From: ivonblumerarchitects [REDACTED]
Sent: 11 May 2017 15:22
To: Simon Davis
Cc: splawren2
Subject: Re: Planning Consultation on AW/73/17/DOC

Information requested now added to drawing IBA/458?LA/1 Rev A.

PROJECT	Kings Parade	DATE	05/03/17
TITLE	Landscaping Plan	DRG NO	IBA/458/LA 1
SCALE	As Noted	REVISIONS	A

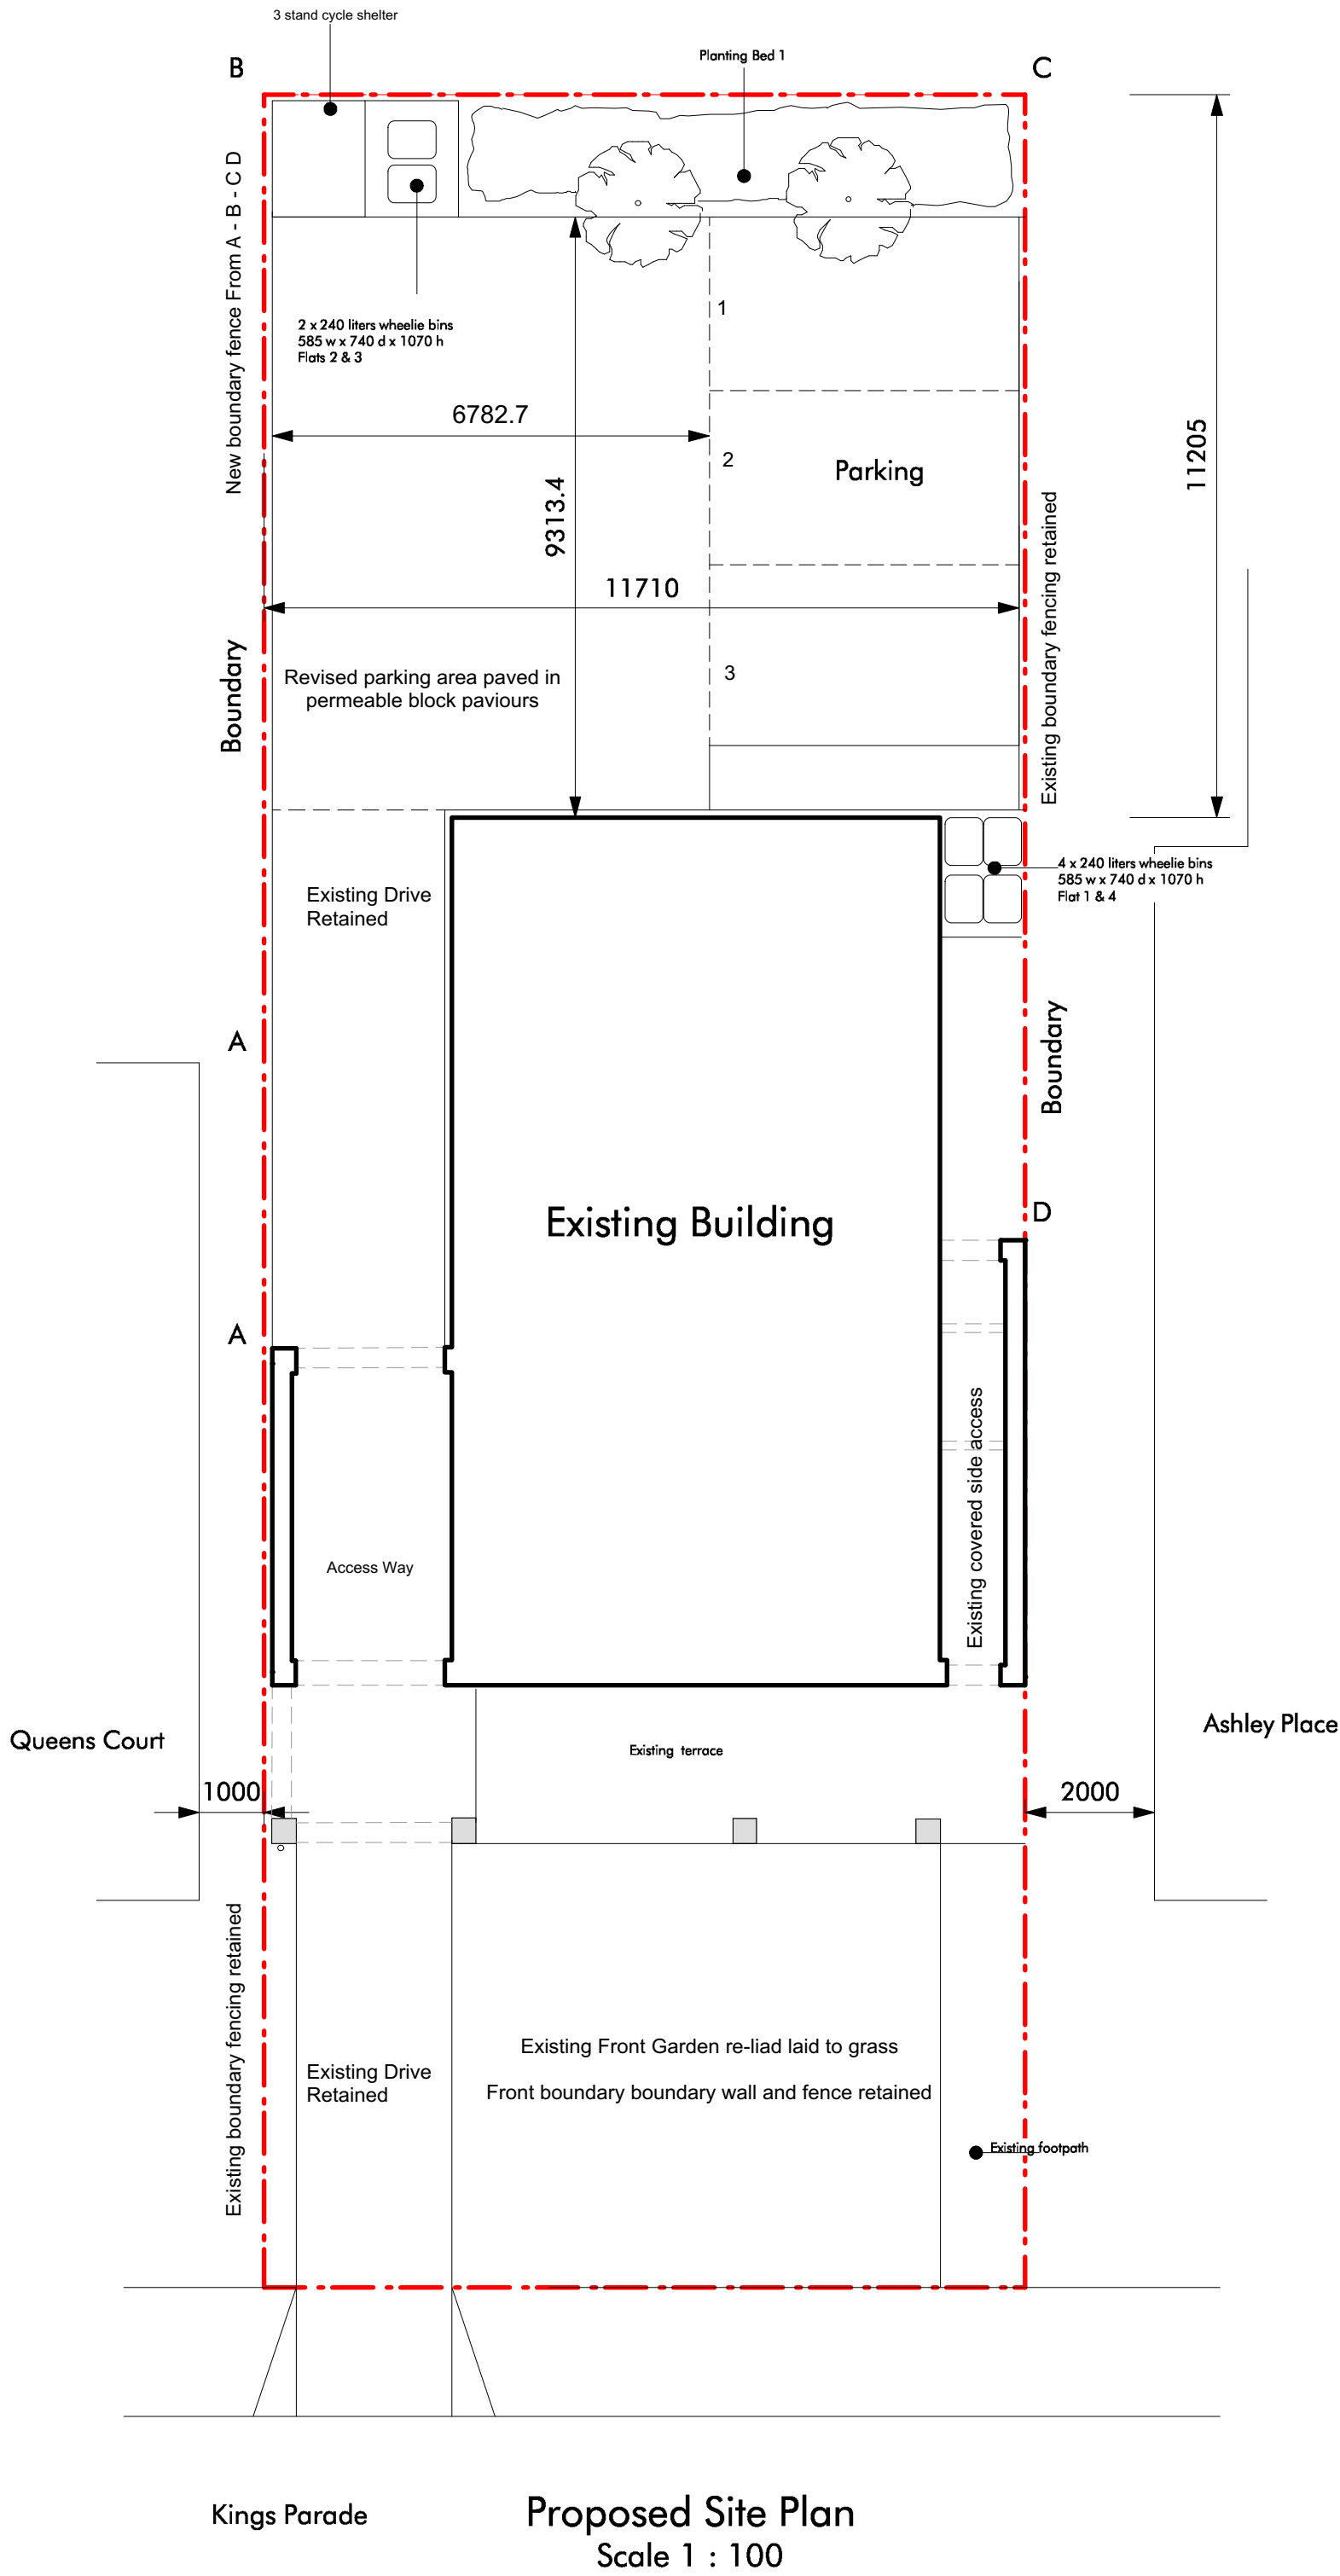
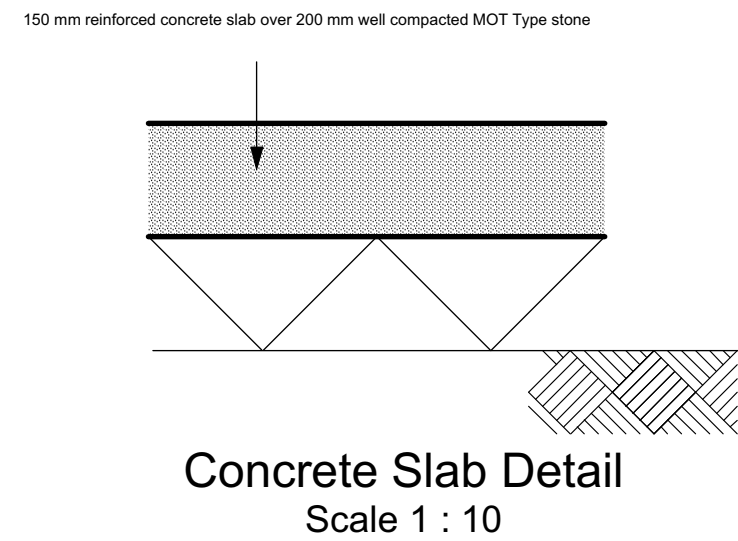
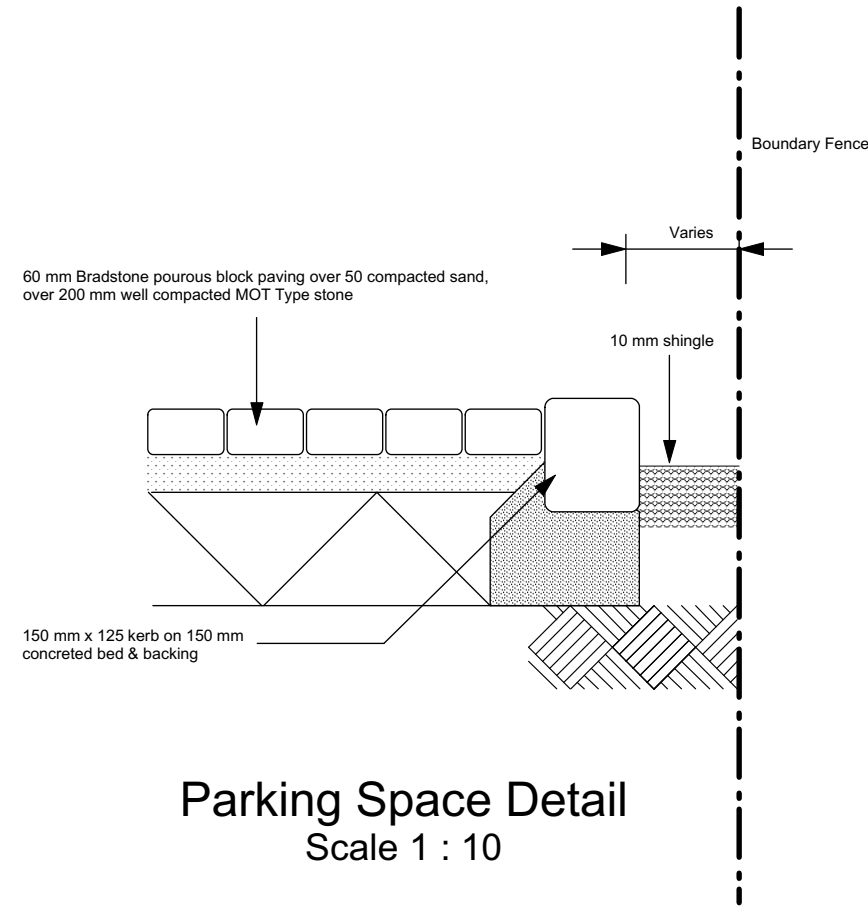
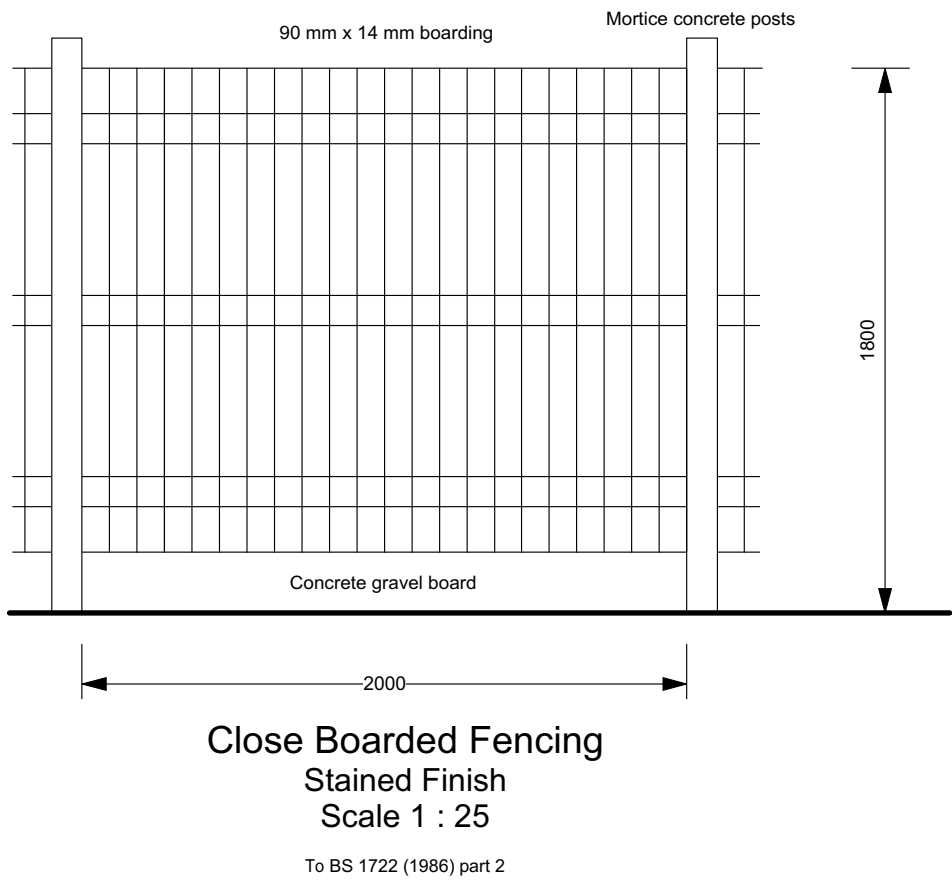
i.e quantity, size and time of planting for shrubs, trust this is acceptable to Greenspace.
